RFI Response | Mixed –use precinct with affordable housing – Crescent Parklands, Holroyd (SSD –70283710)

This letter relates to State Significant Development Application SSD–70283710 for the proposed mixed-use precinct development, including seven residential tower buildings, an eastern mixed-use podium and associated car parking at 1 Cresnet Street, Holroyd (the site).

PUBLIC OPEN SPACE = 10,068.46 m2,	26.58%
	COMMUNAL OPEN SPACE = 8,235.33 m2,	21.74%
	TOTAL OPEN SPACE = 18,303.79 m2	48.32%
TOTAL SITE AREA = 37,877 m2

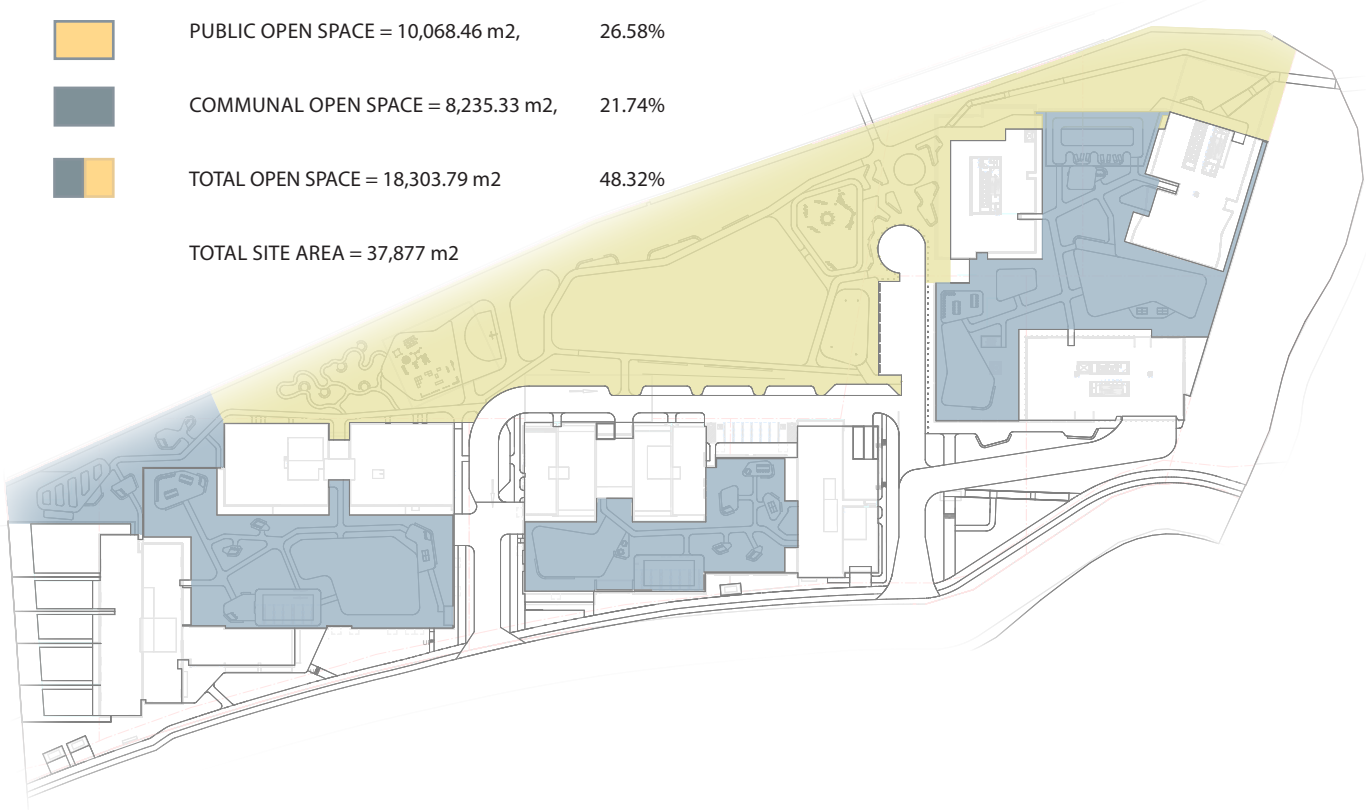
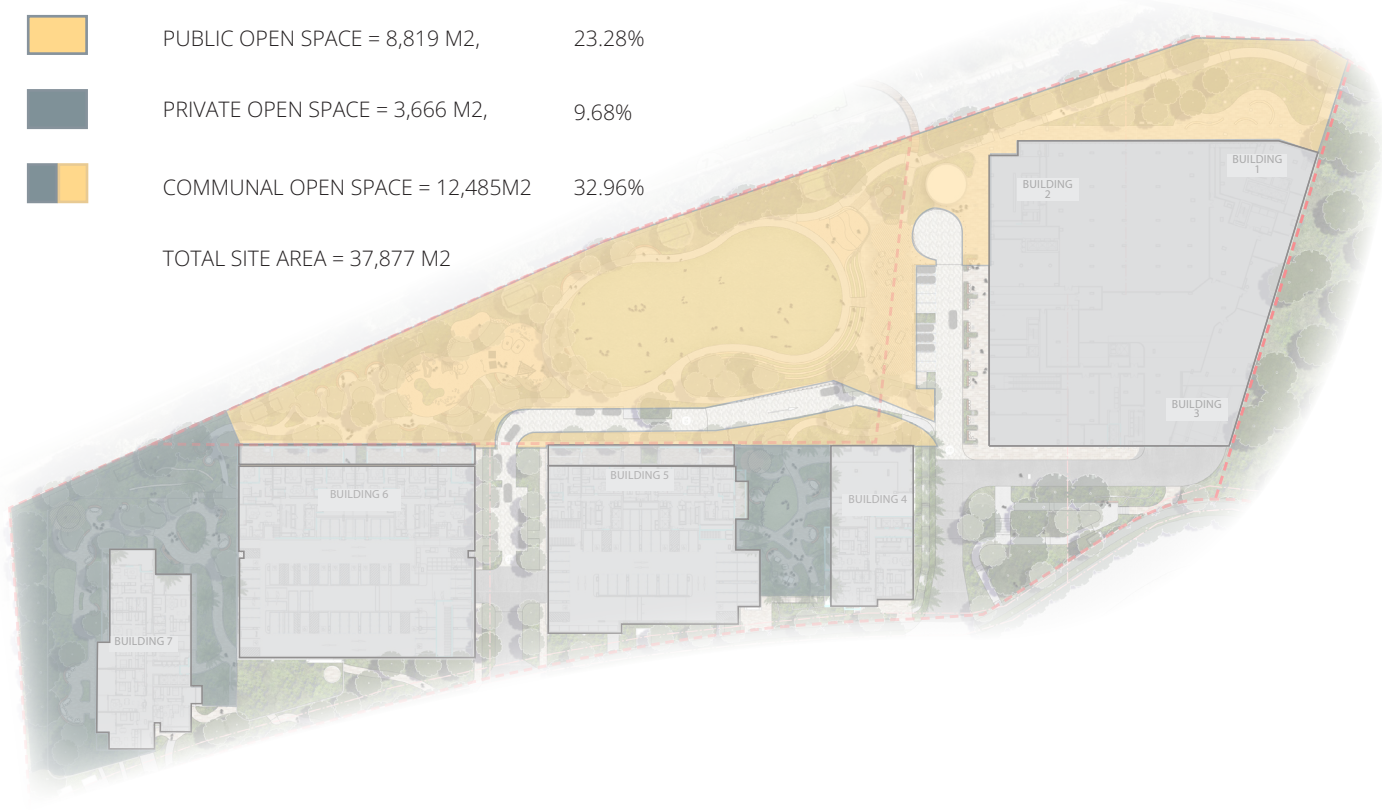
1. The site-wide open space calculation at pages 23–24 of Appendix D (Landscape Report) (18,303 m²) is inconsistent with the site-wide open space calculation at page 2 of Appendix A(3) (18,157.73 m²). Update and clarify.

2. The response did not provide a clarified breakdown of the open space calculations as requested. See annotated image below.

Arcadia note there was an area discrepancy created by CAD.

A clear break down of the open space calculations has been provided by Woods Bagot, refer to Appendix A.
